KITTITAS COUNTY COMMUNITY DEVELOPMENT SERVICES

RE: Nelson Agriculture Short Plat, SP-15-00010

SUBJECT: JN Agricultural Short Plat SP-15-00010

RE: SP-15-00010 Nelson Agriculture

Critical Areas  
Map

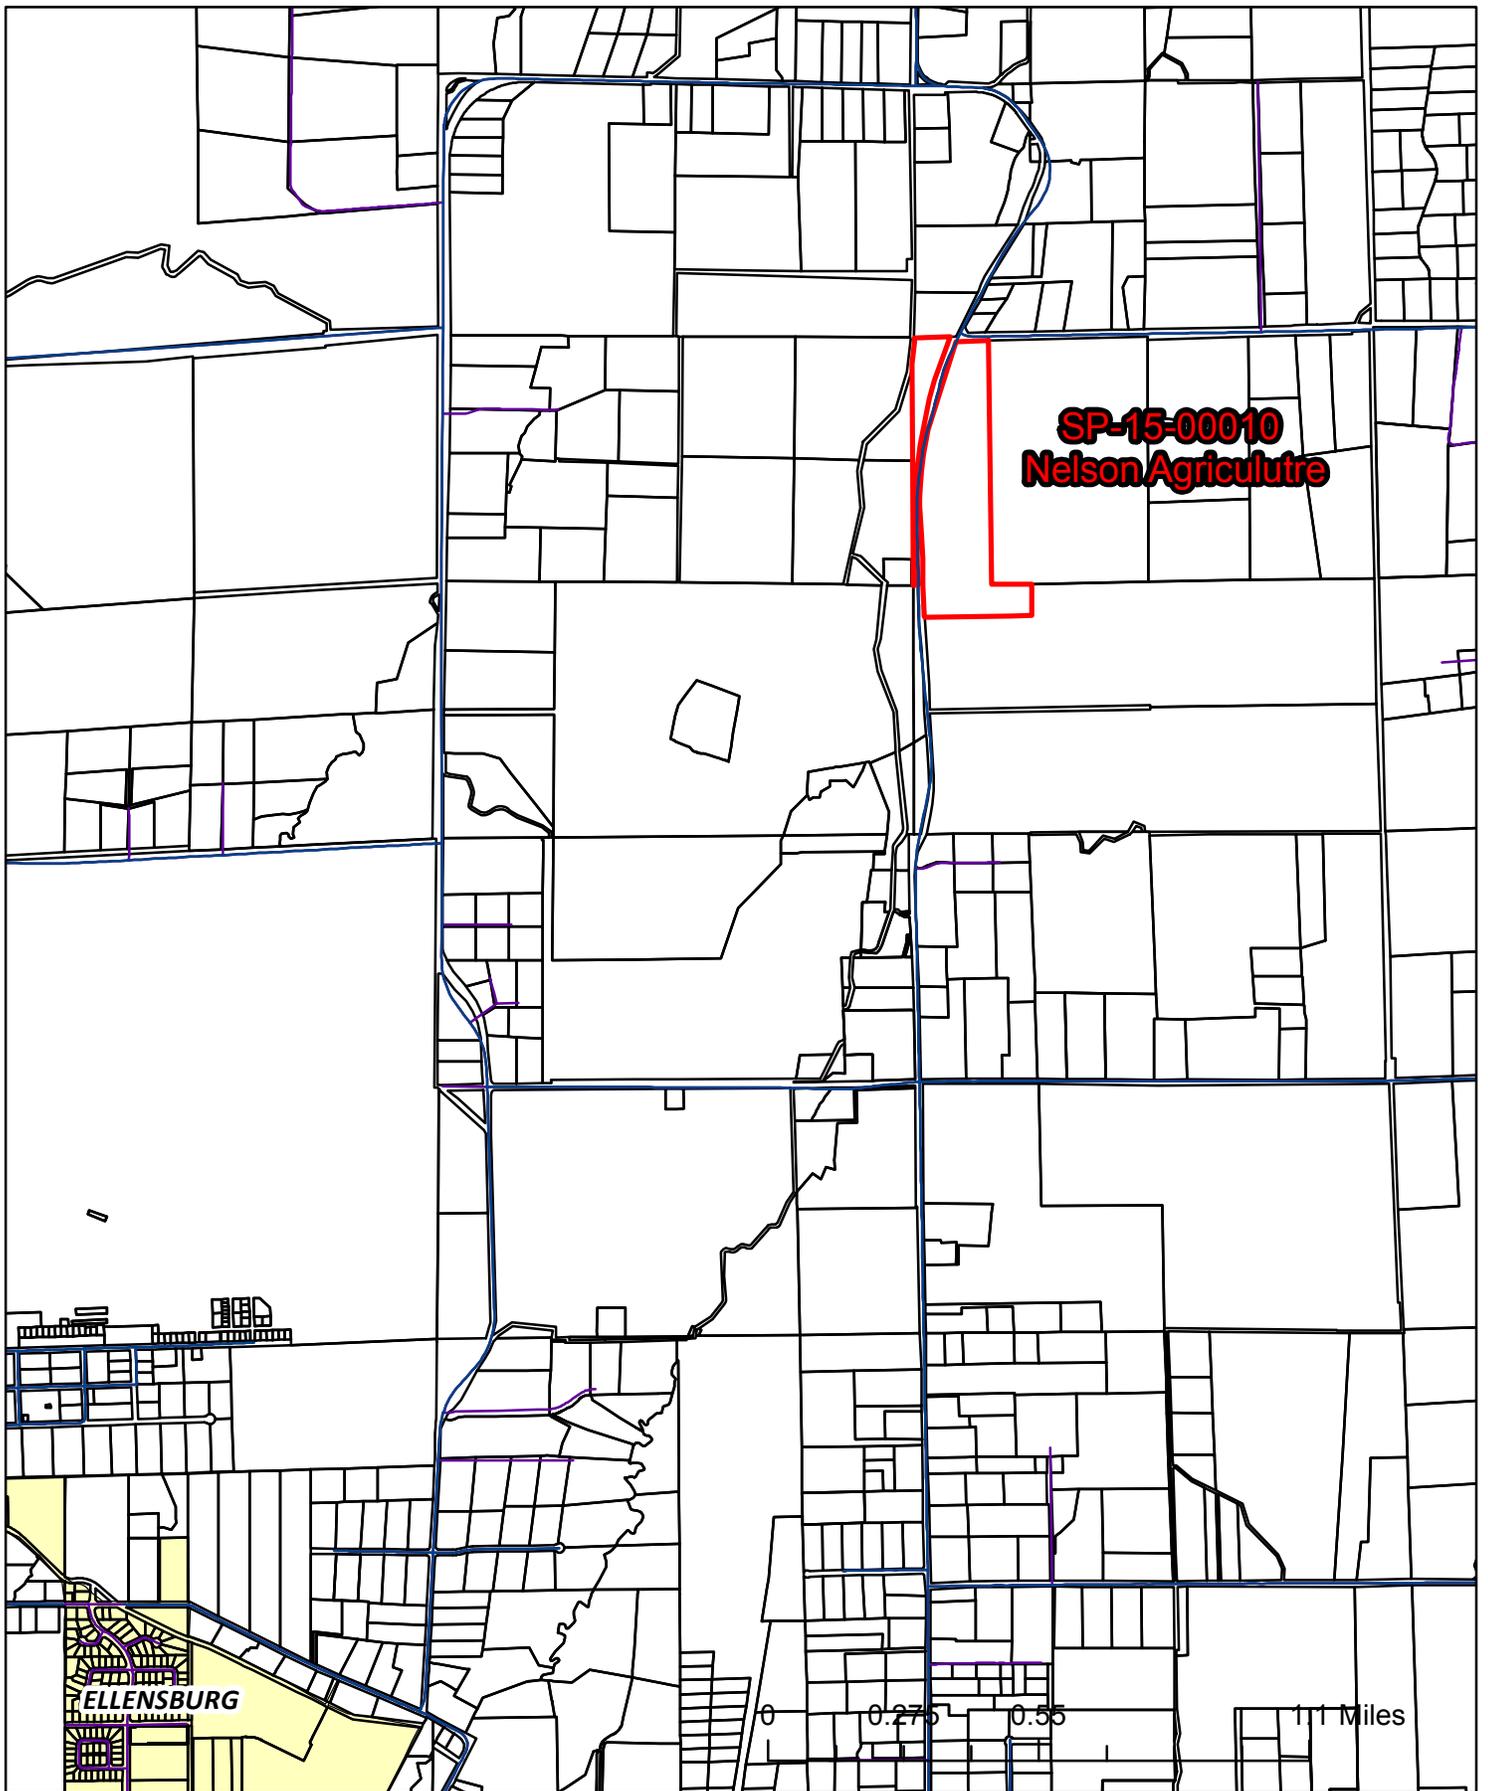
It appears that the wrong critical areas checklist may have been posted in the file for this project on the County website

**JN AGRICULTURAL SHORT PLAT**  
PREPARED FOR  
JOAN NELSON  
A PTN. OF THE WEST 1/2 OF SECTION 17,  
TOWNSHIP 18 N., RANGE 19 E., W.M.

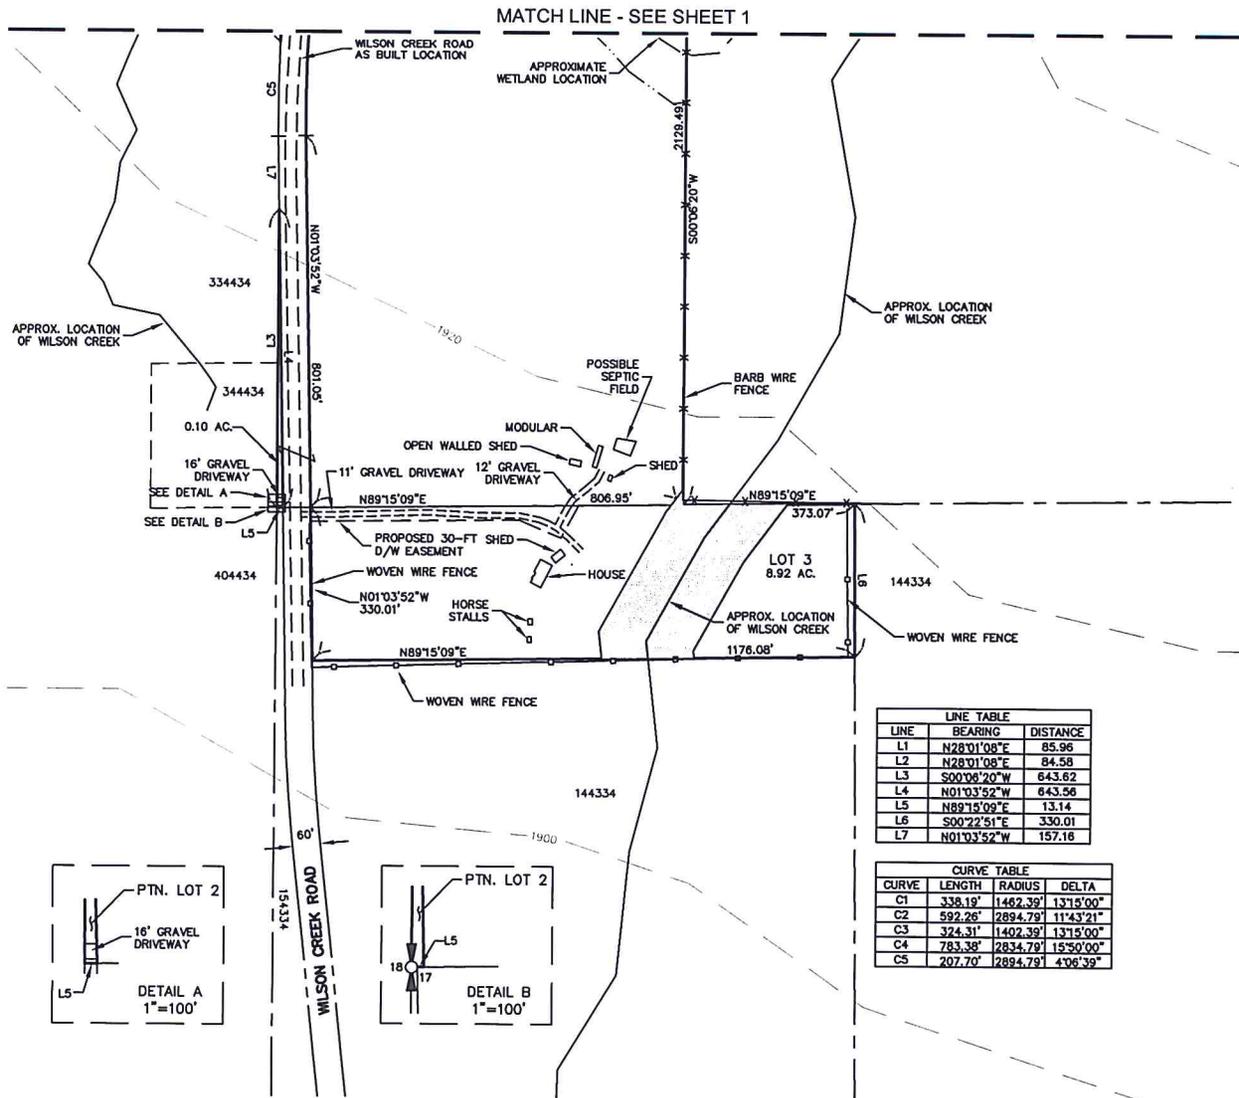
1. Transportation Concurrency Application: Needs to be submitted to Public Works.
2. Neighboring Property Access: Easements for access across lot 2, for parcels 047736, 334434 and 344434, need to be documented on the face of the short plat.

3. 100 year floodplain: 100 year floodplain located on westerly portion of lot 2, needs to be shown on the face of the short plat.
4. Driveways: A driveway shall serve no more than two tax parcels. See Kittitas County Road Standards, 12/15/15 edition.

The current drawings do not include existing wells properly marked with clear setback measurements from structures, septic system components and boundary lines.
